CITY OF ALBUQUERQUE

RE: **Lot 22 Block 1 Volcano Cliffs Unit 22 SAD 228**
8008 Agua Fria Ct. NW
Grading and Drainage Plan
Engineers Stamp Date: 10/29/2020 (D10D003N22)
CO Certification Date: 6/15/2023

Based on the Certification received on 6/16/2023, the site is not acceptable for release of Certificate of Occupancy by Hydrology until the following comment is addressed.

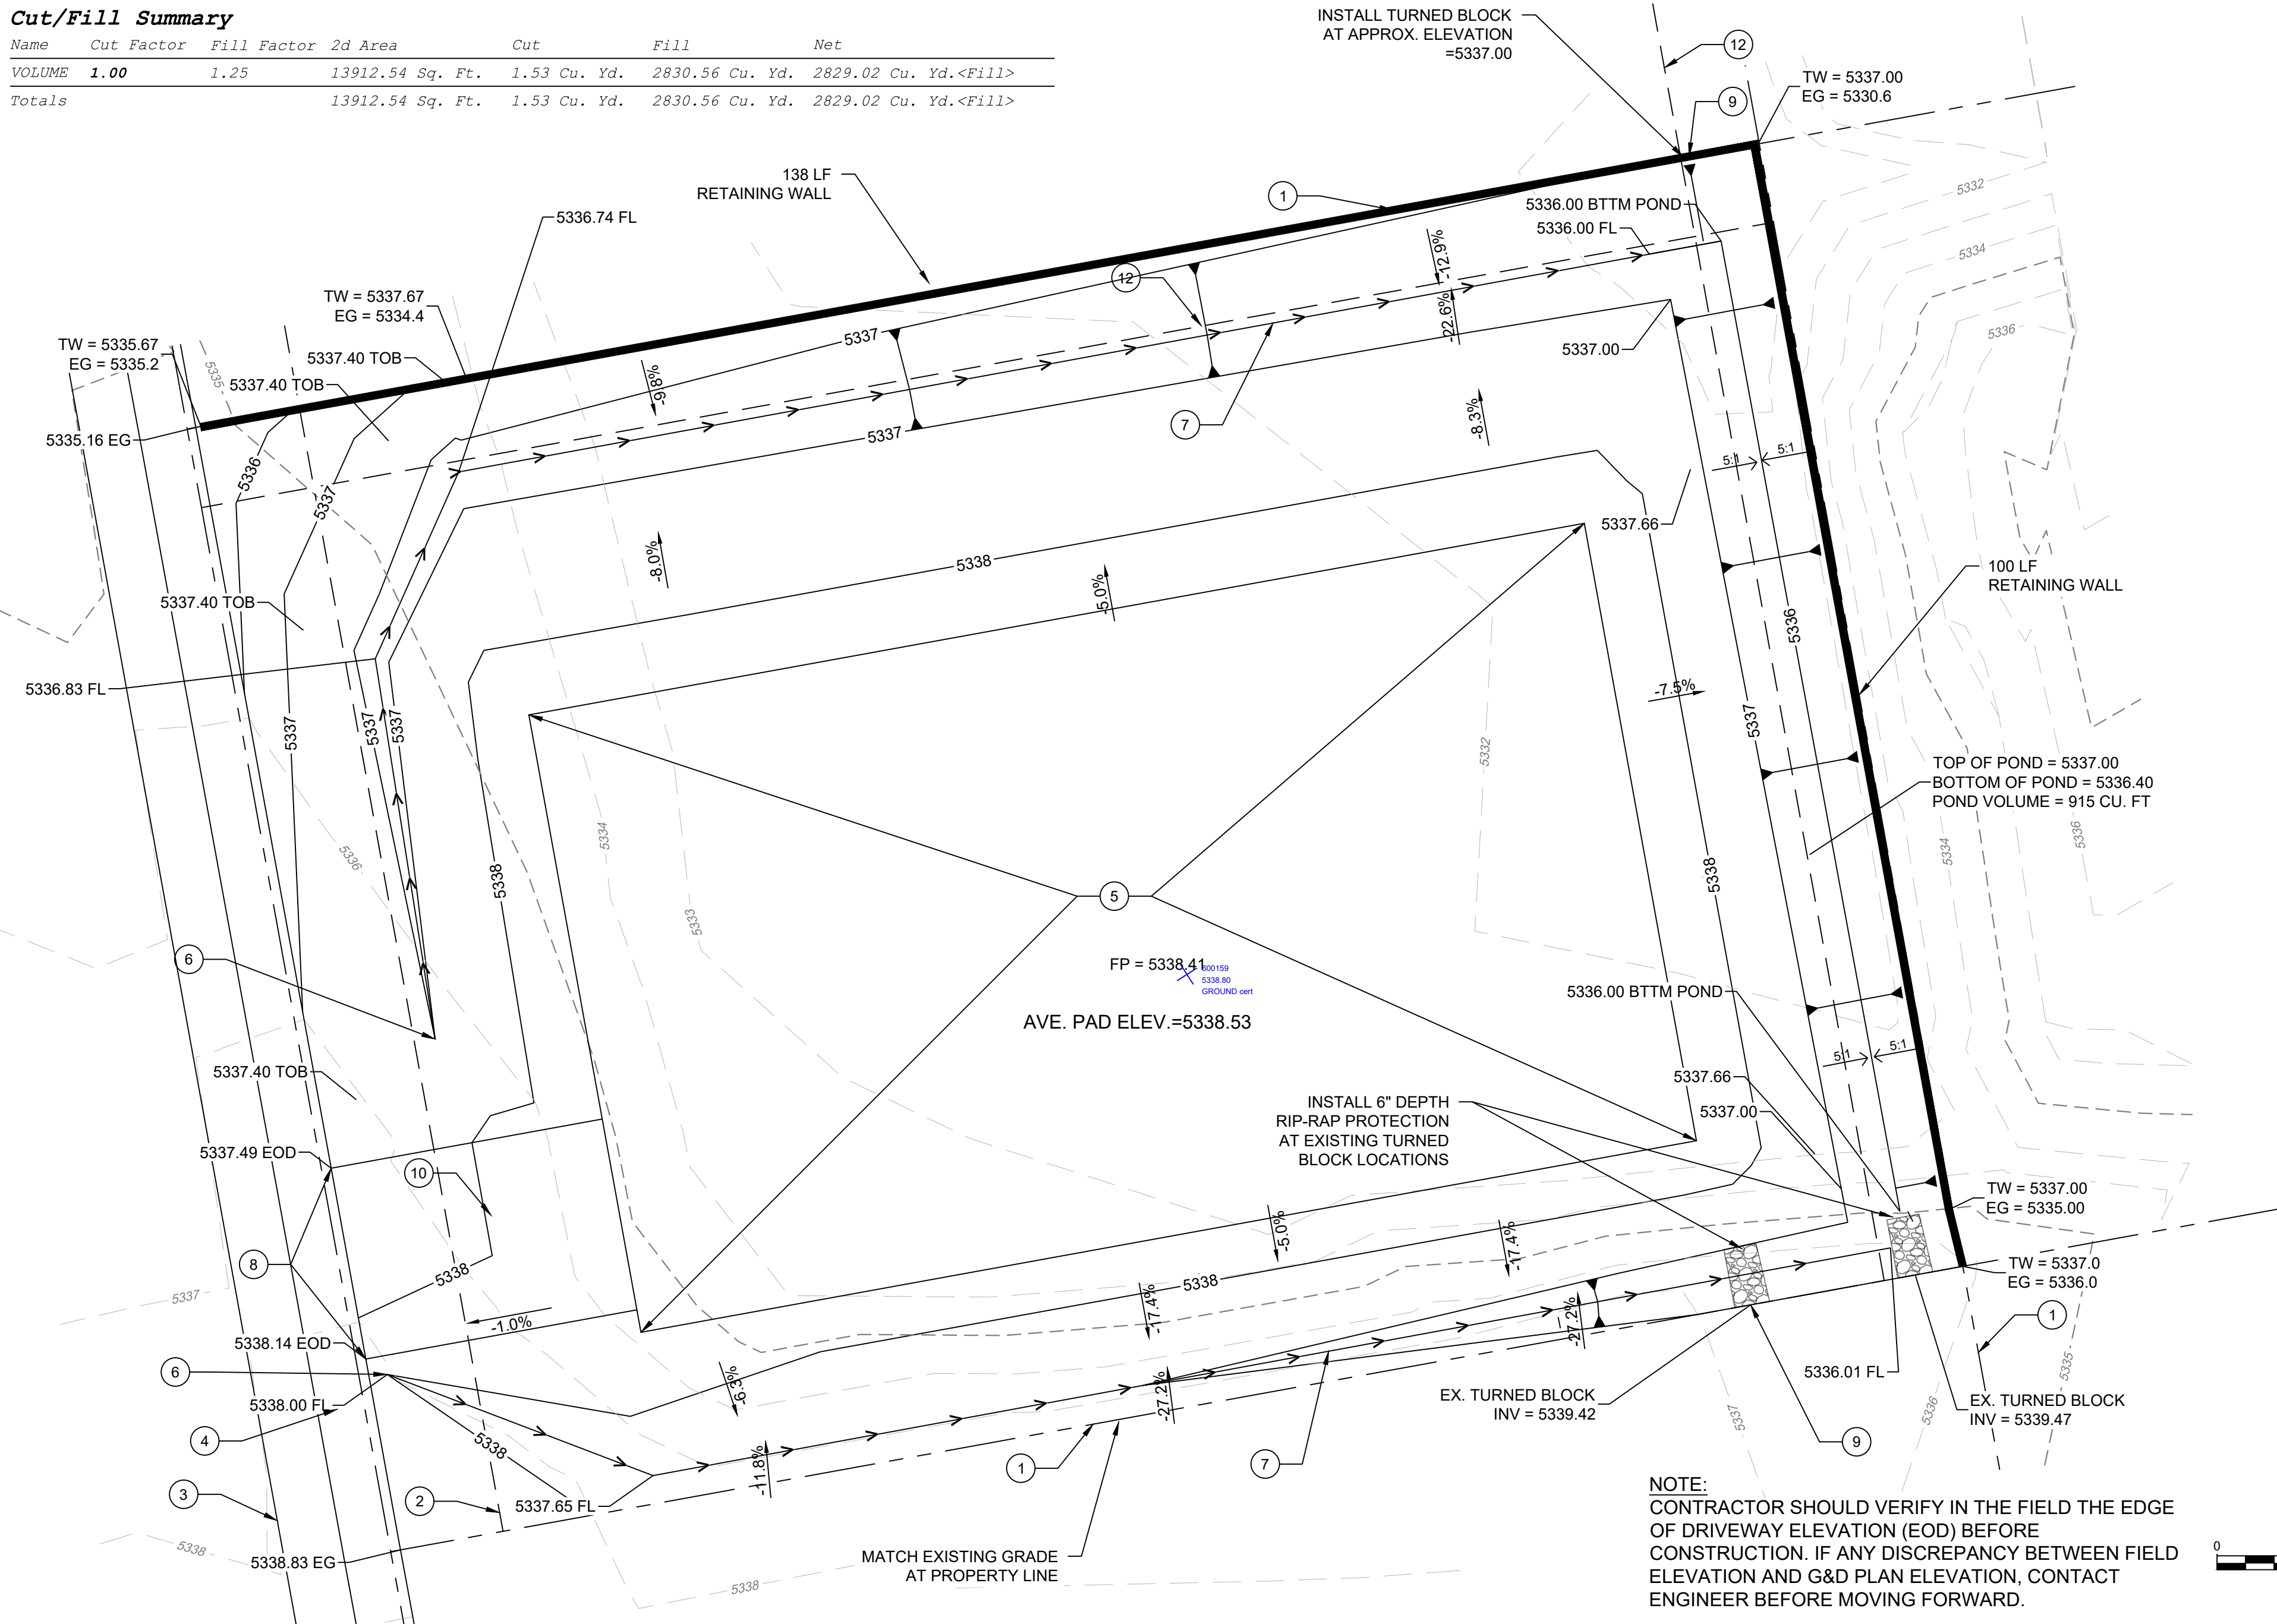
- The channel going from Alto Rey Ct to Agua Fria must be cleaned and free of debris.
